**Application by Elements Green Trent Limited for an Order granting Development Consent for the Great North Road Solar and Biodiversity Park**

**Planning Inspectorate Reference Number: EN010162**

**Deadline 1: Written Representation and Summary submitted on behalf of National Highways Limited**

**Abnormal Load Routes
Figure A5.2.2**

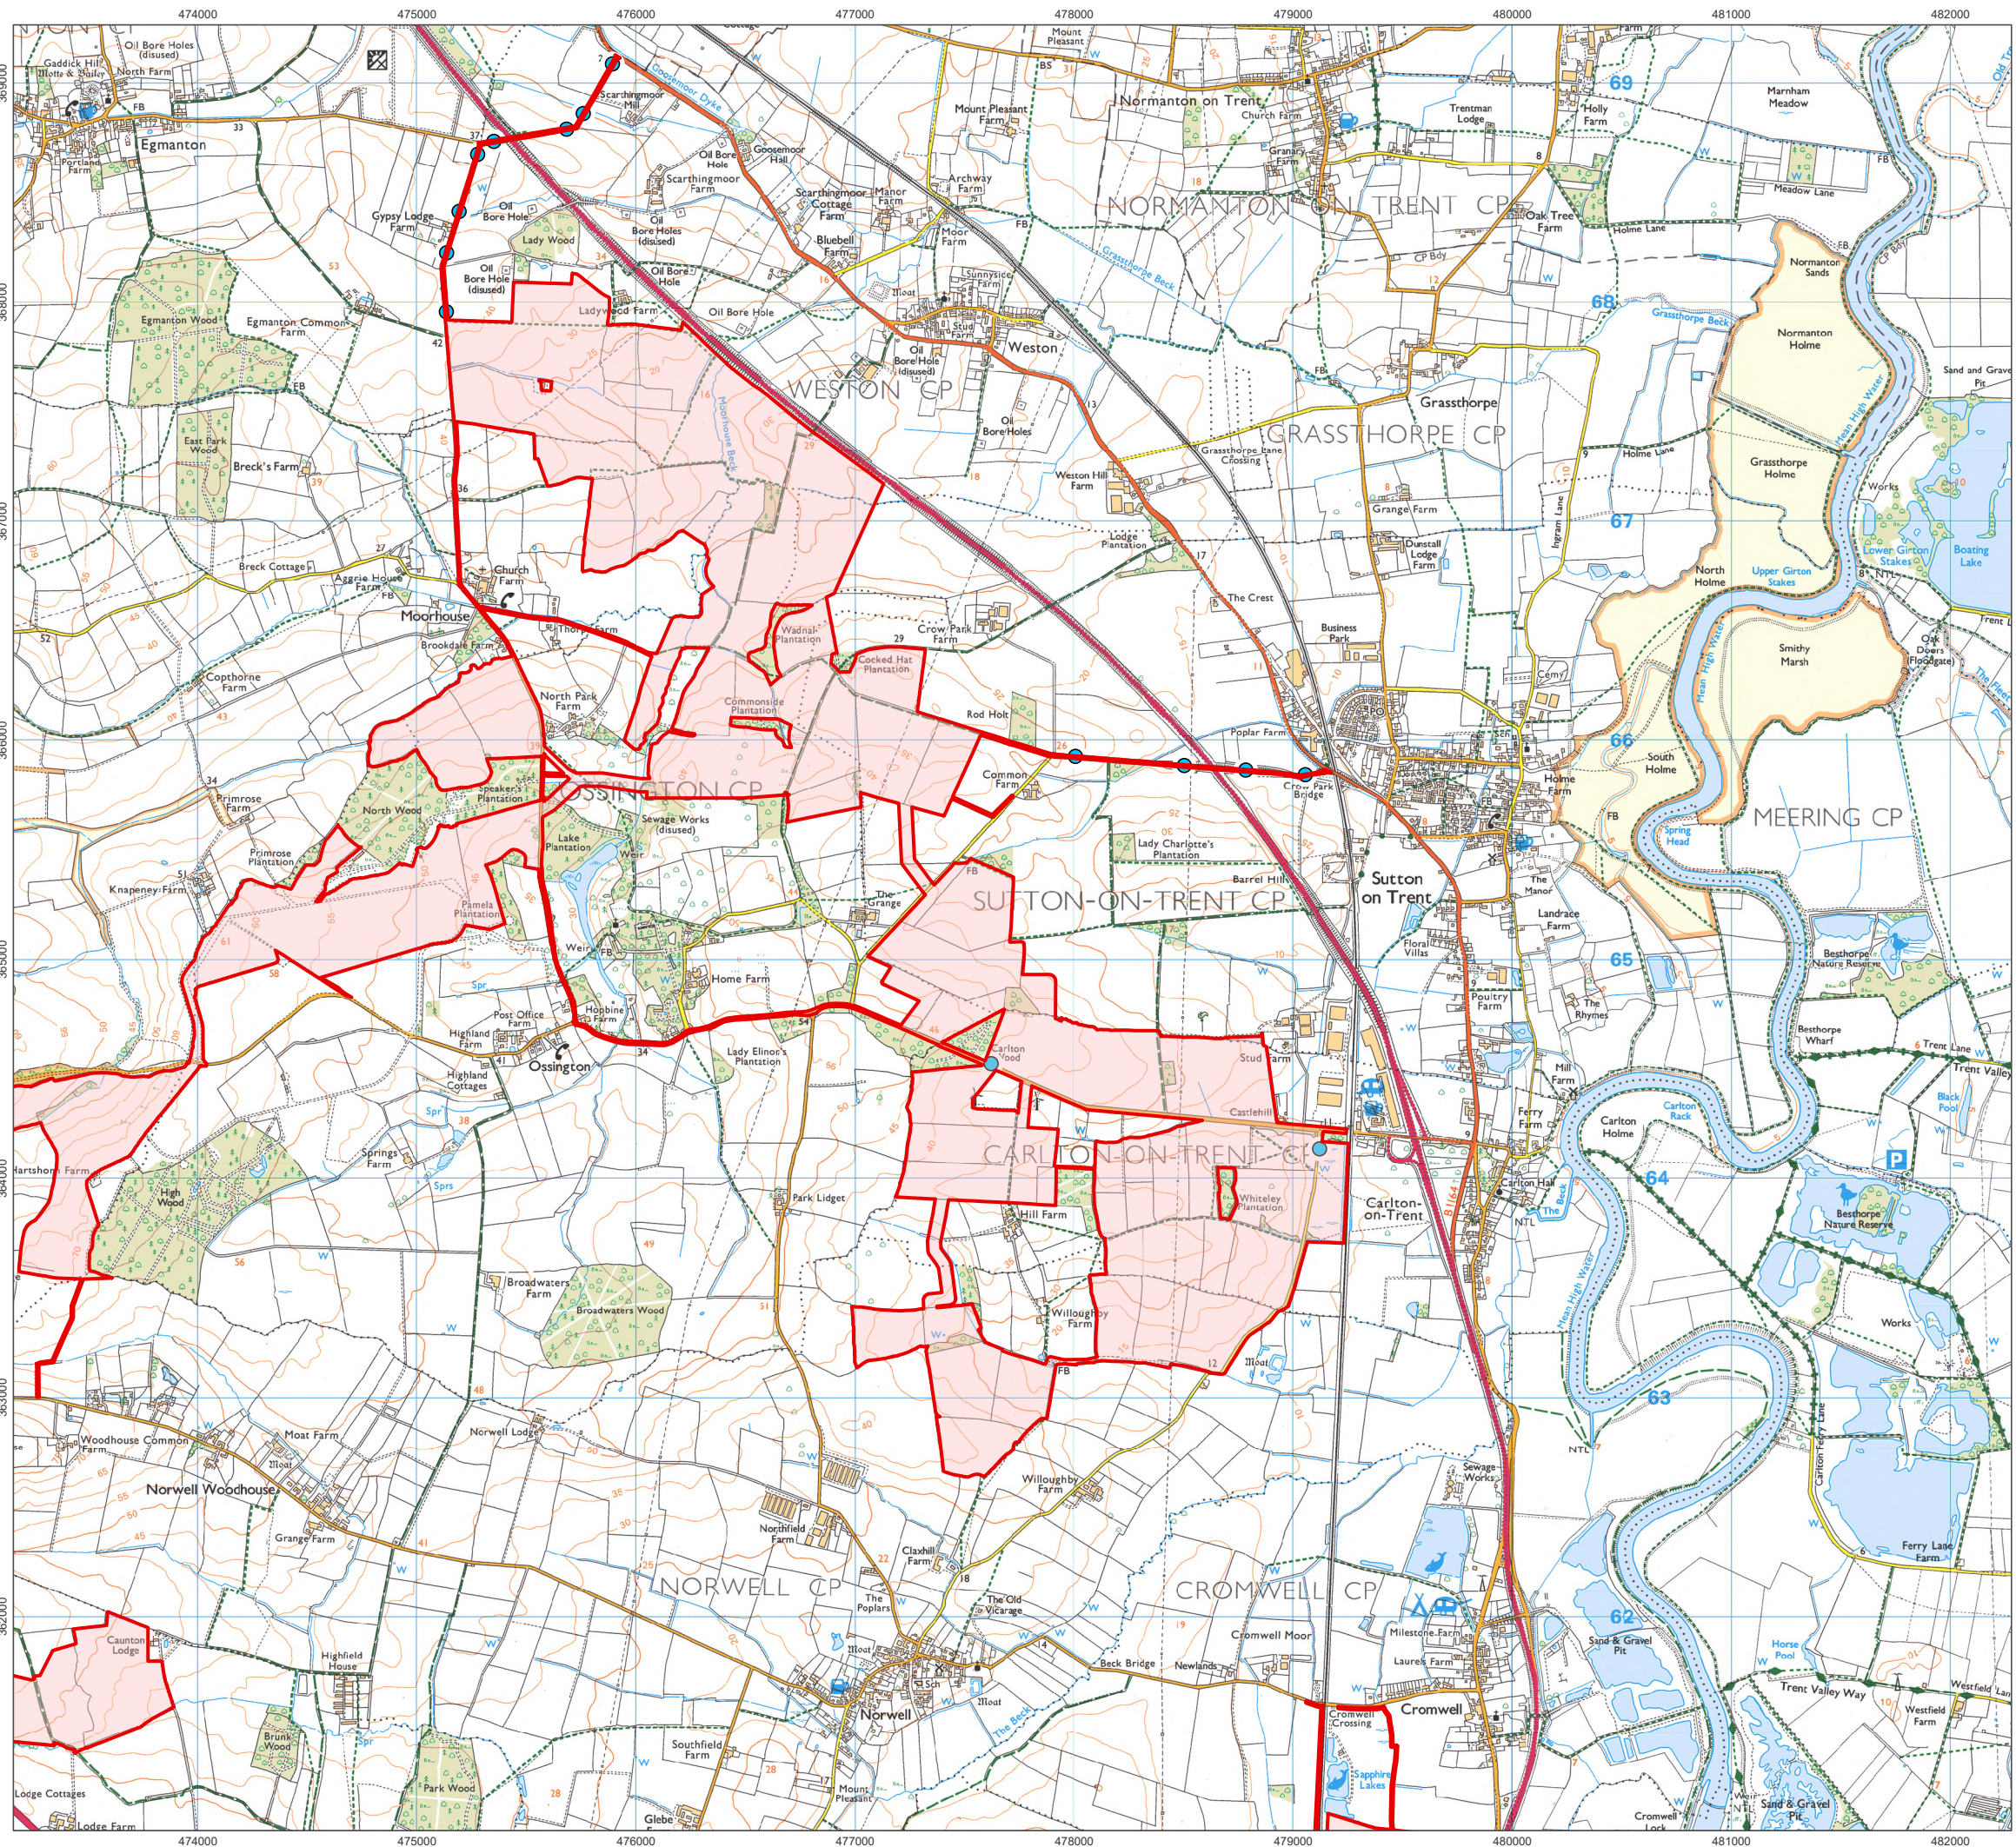
- 5.1. As noted in the NH relevant representation, NH has requested information on various matters to enable it to form a conclusion on the impact on the SRN particularly with regard to junction capacity. This includes:
- (b) Trip generation hourly peak traffic flow figures;
  - (c) Trip distribution flow diagrams for construction traffic;
  - (d) Further information on the geographical area selected to calculate the growth factors and separate growth factors for the AM and PM peak hours;
  - (e) Assessment of growth factors using the most recent version of the TEMPro software and clarification of all inputs into TEMPro for NH's review;
  - (f) Swept path analysis of the A1 for abnormal indivisible loads and the provision of drawings for NH's review;
